Please attach to the application as substitute plan to Sheet 2 of 3.

Pleased to attach amended plan with one level skirt roof.

sheet 2 of 3

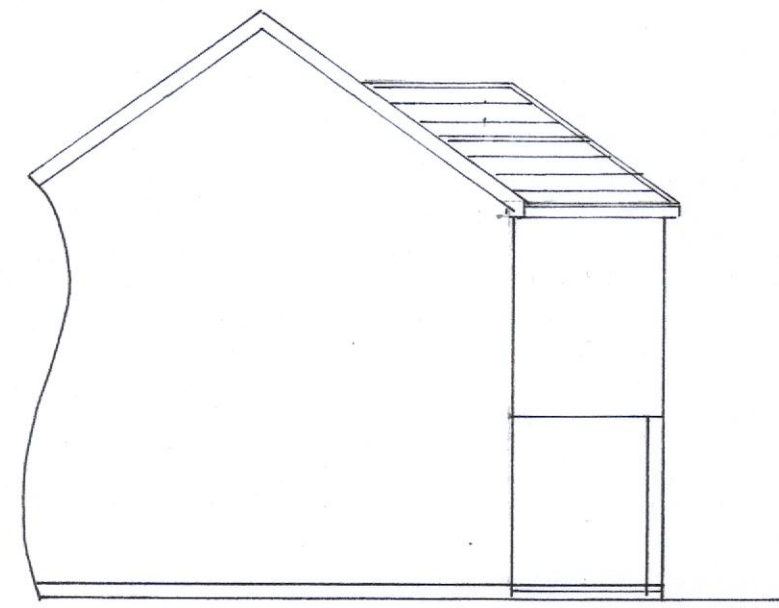
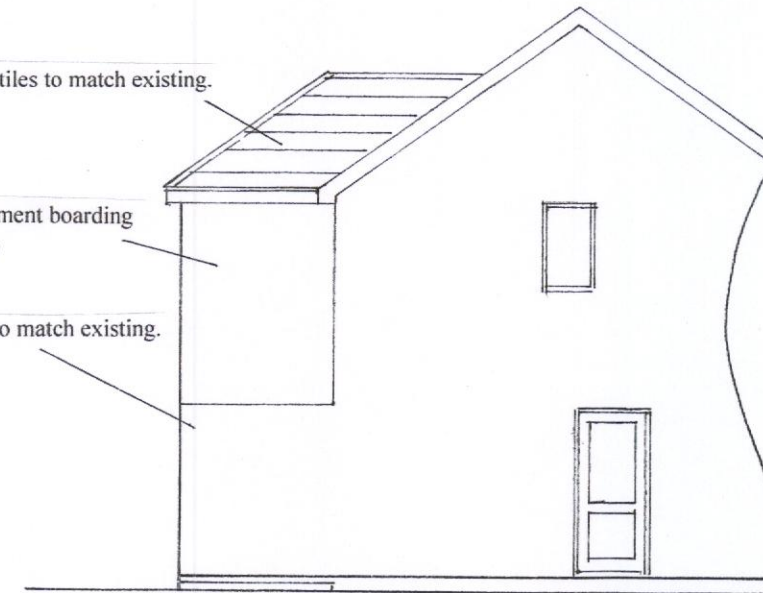
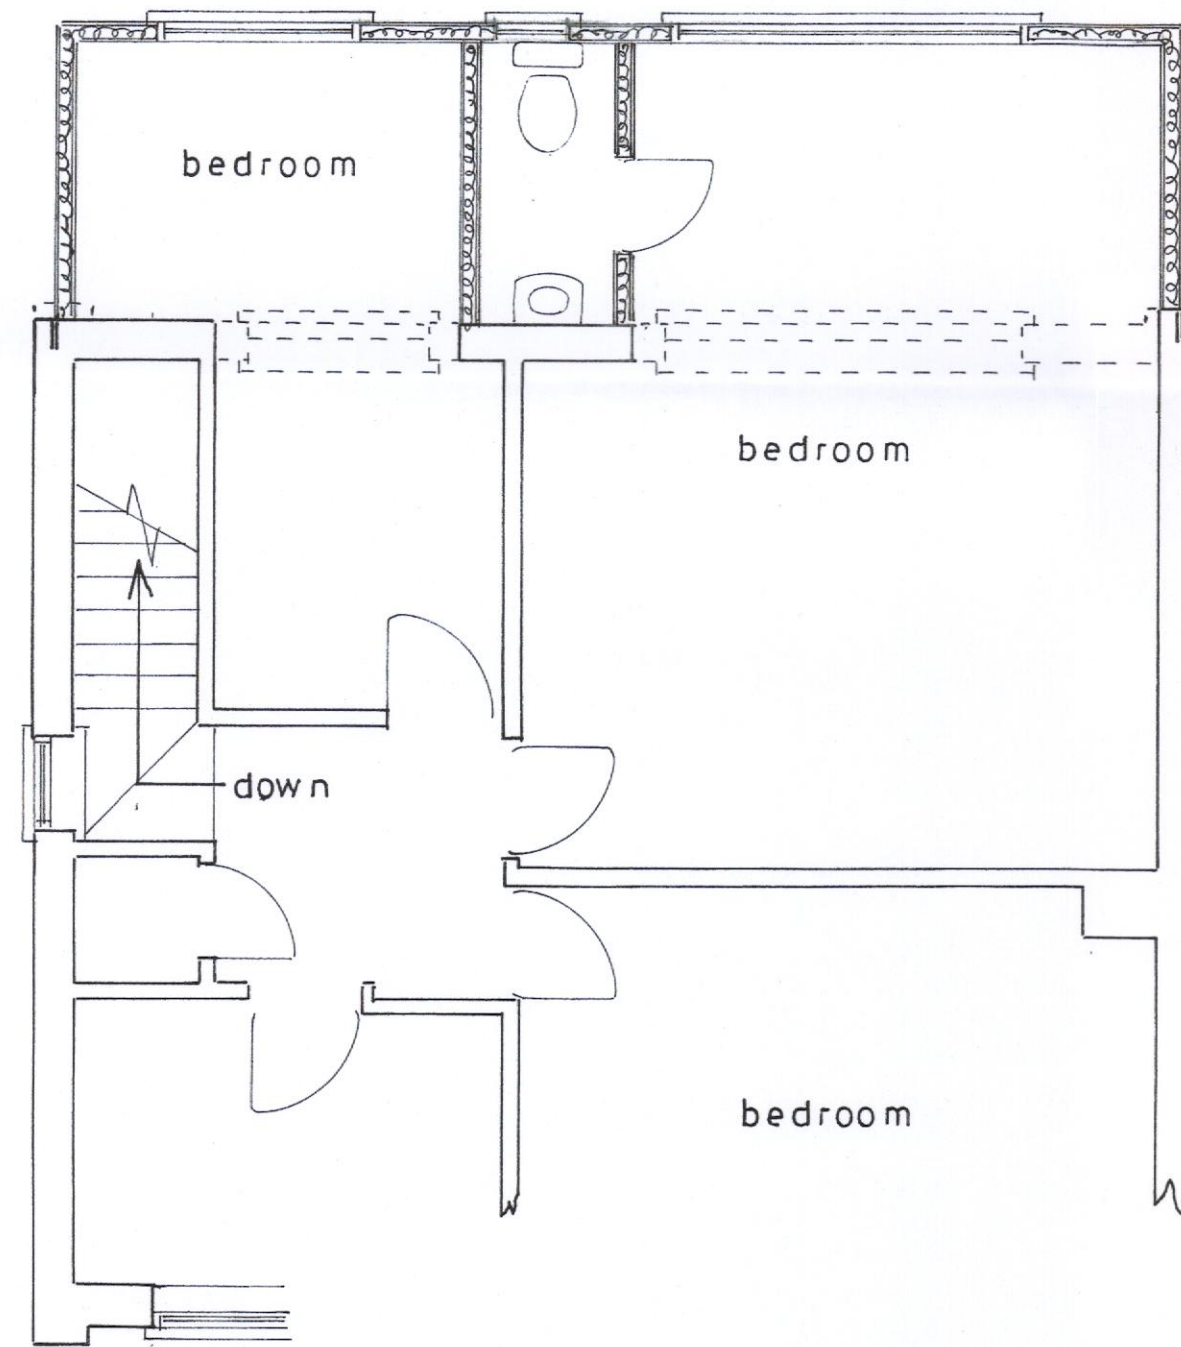
I have started going through the application for 61 Queens Fields West. The Parish Council have objected due to the impact on the character of the area and that the proposed extension is not visually integrated. As the application is I would agree with them. For me this is due to the proposed roof, are there any changes to the roof available to reduce the impact, I would look to have the roof one level so there is not the change part way along which would draw attention.
